Rezoning Transportation Analysis

Petition Number: 2020-122

General Location Identifier: Tax ID (02718124)

RZ-1.0

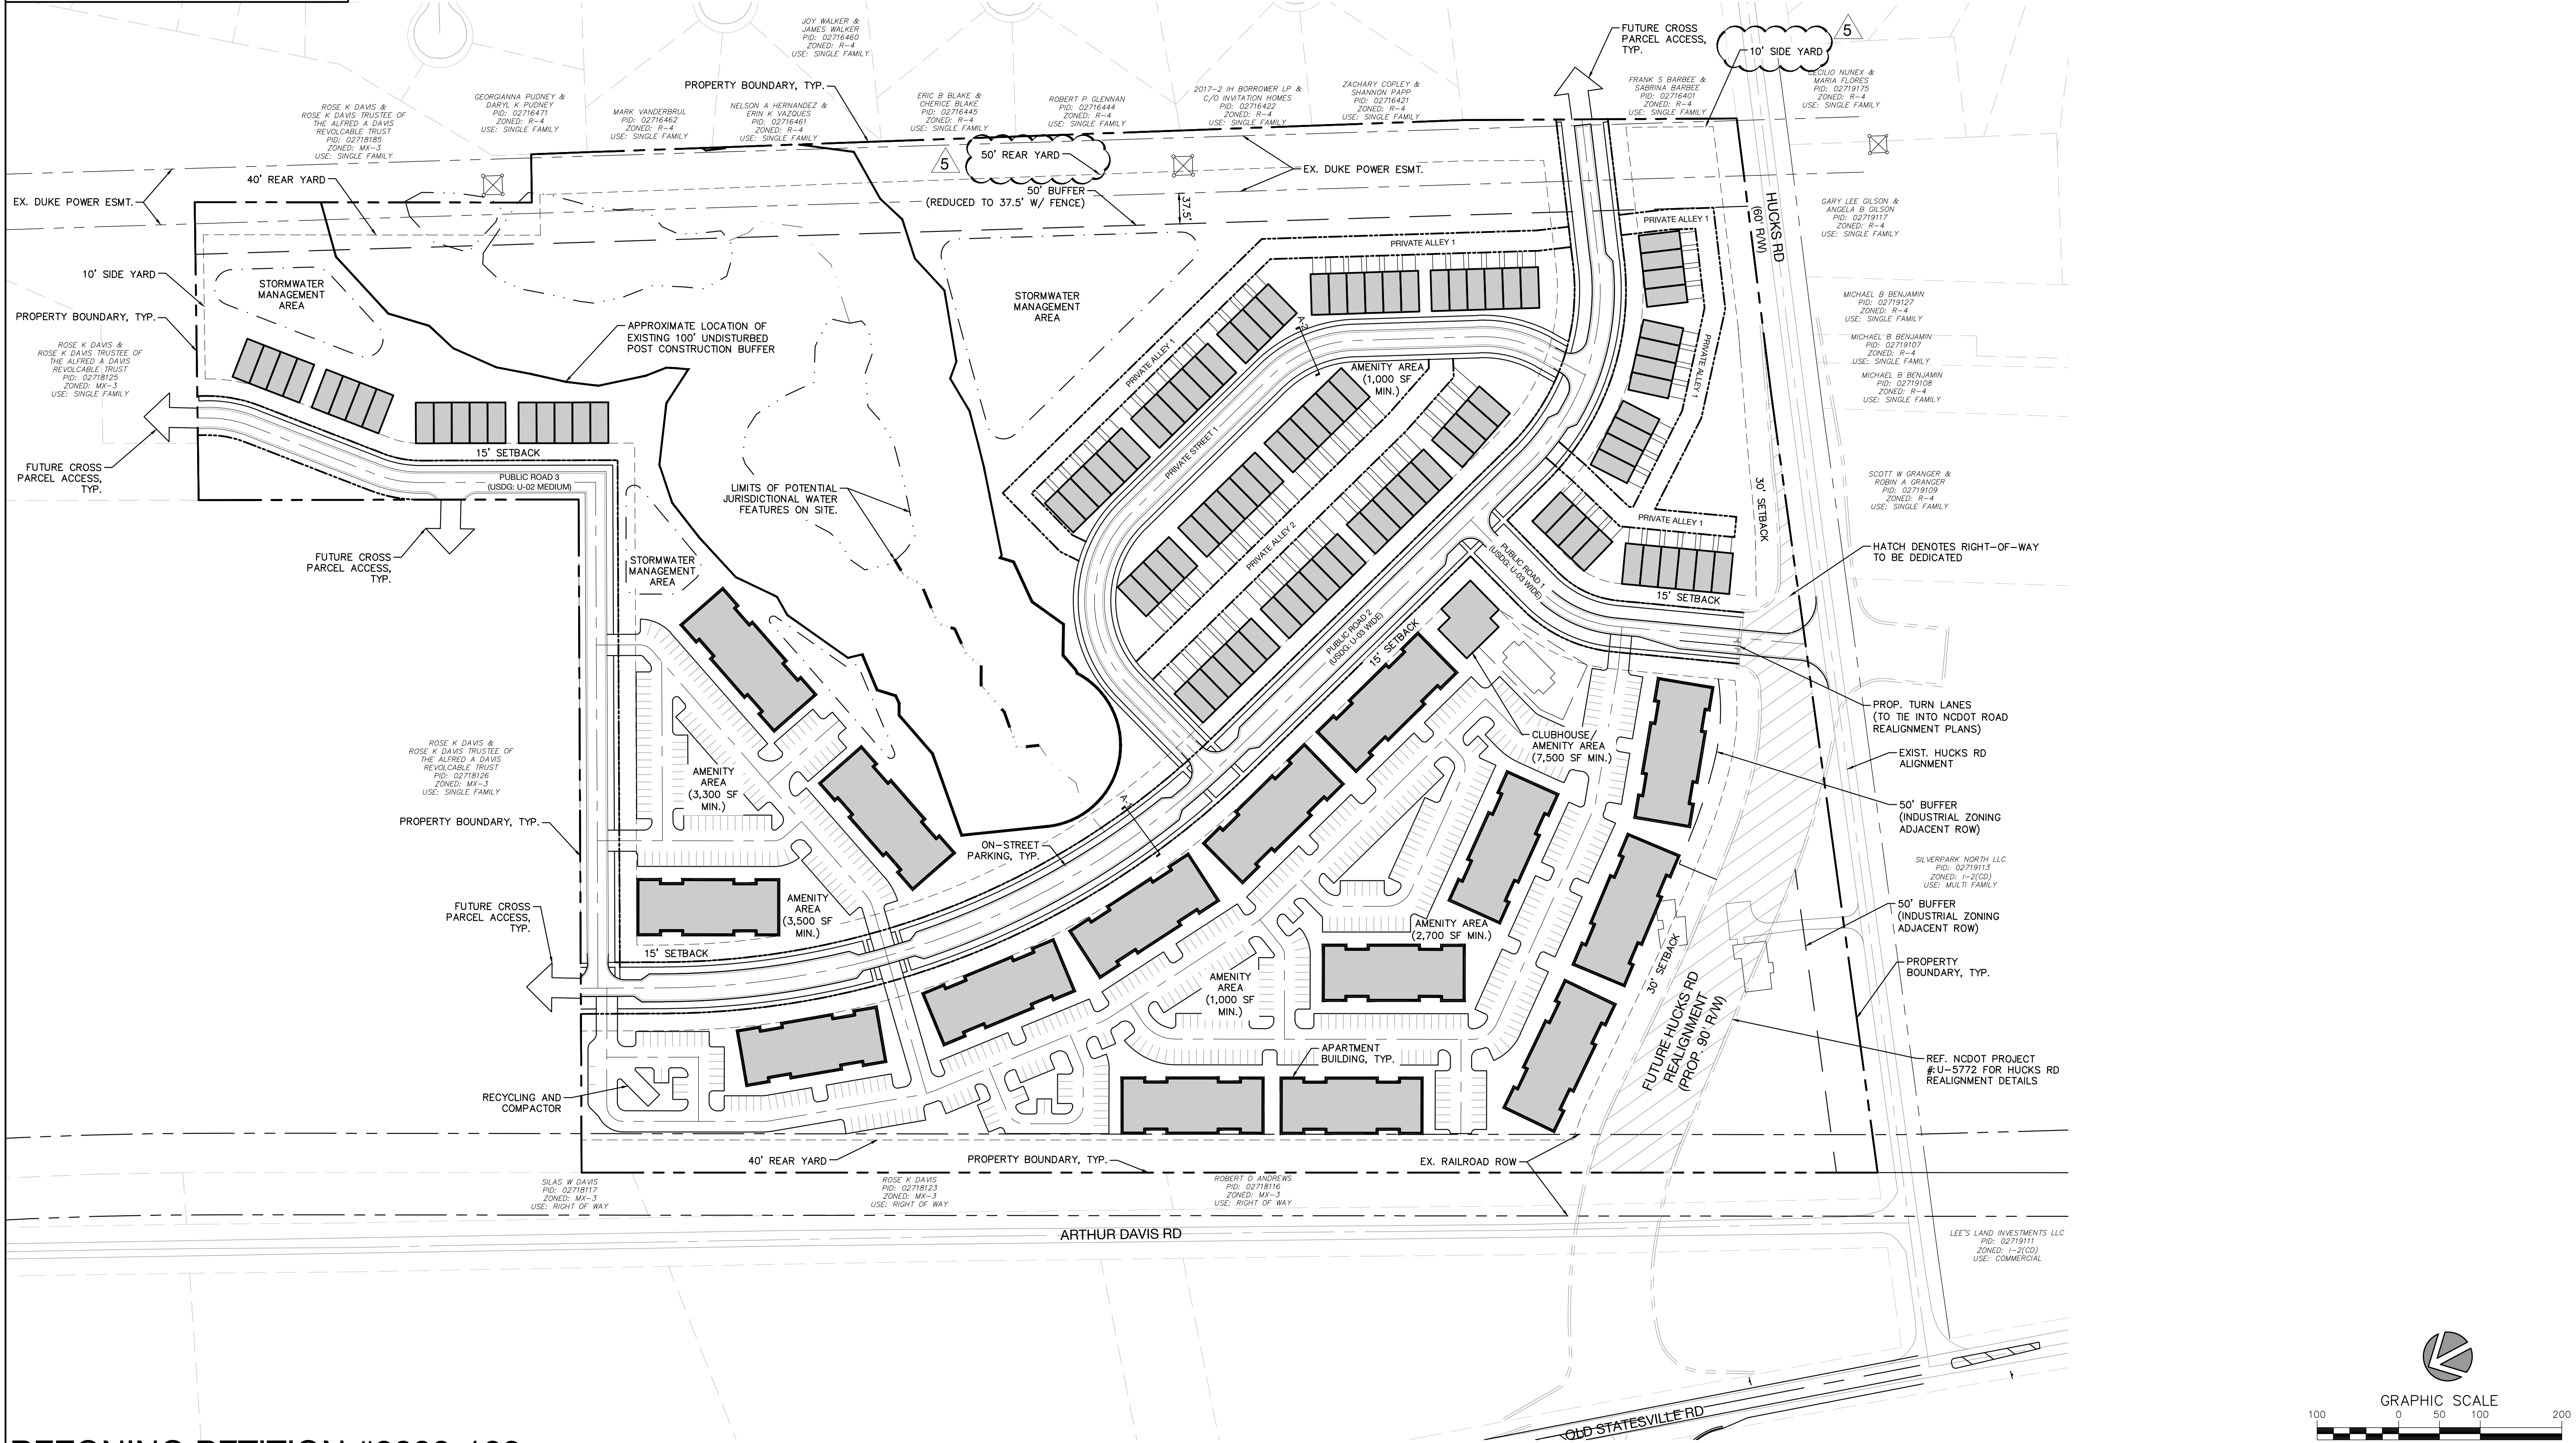
3. ~~Outstanding (site plan dated 10.12.20):~~ Revise the site plan and conditional note(s) to commit to dedicate right-of-way for the Hucks Road Realignment, labeled and dimensioned for the total right-of-way dedication width.
4. **Rescinded:** Revise the site plan and conditional note(s) to commit to construct the portion of Hucks Road Realignment that is graphically depicted on the site plan sheet **RZ-1.0**, to match the approved TIS scope.
5. ~~Outstanding (site plan dated 10.12.20):~~ Revise the site plan and conditional note(s) to include the roadway improvements that are required within the final approved TIS.
